**From:** Contact Centre (CRM) <contact@ribblevalley.gov.uk>  
**Sent:** 18 March 2022 09:47  
**To:** Planning  
**Subject:** Planning Application Comments - 3/2022/0185

**Planning Application Reference No.:** 3/2022/0185

**Address of Development:** 7 Timbrills Avenue, Sabden

6417-P01 REV A

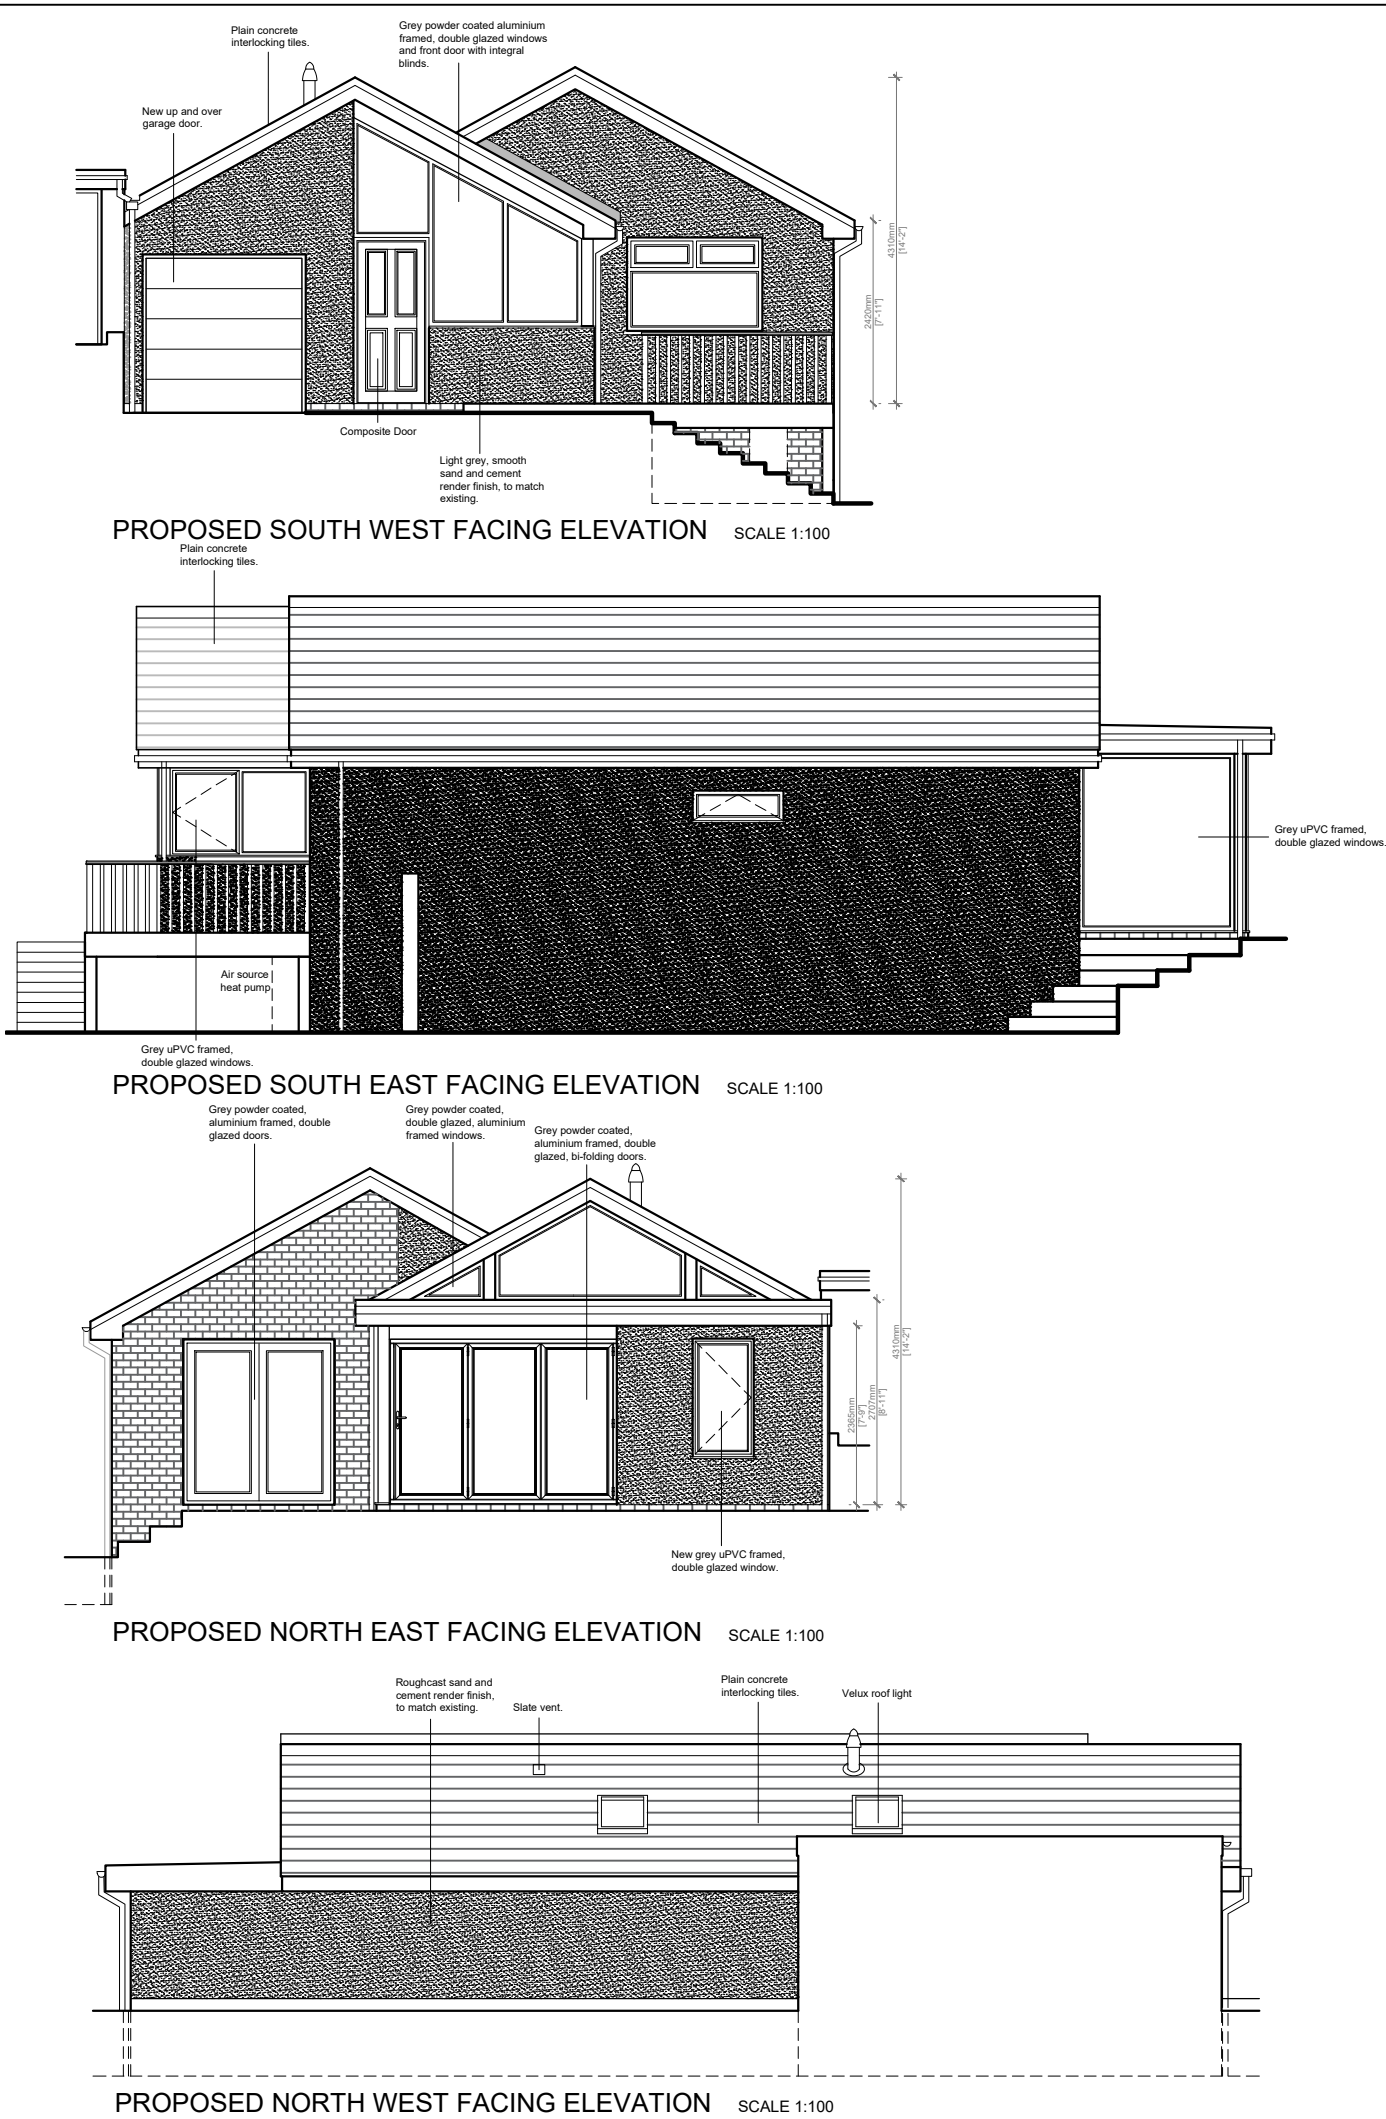
**Comments:** [REDACTED] and no. 7 [REDACTED] were designed as, link detached properties, separated by [REDACTED] two garages. This gives space and light [REDACTED] the proposed application brings the main body of no. [REDACTED] (loosing one garage width) and has a much higher wall at the boundary, there will be reduced light [REDACTED]

[REDACTED]  
[REDACTED] Because of the [REDACTED] and height of the proposed north-west wall of no.7, [REDACTED] windows will receive less light than they do now [REDACTED]
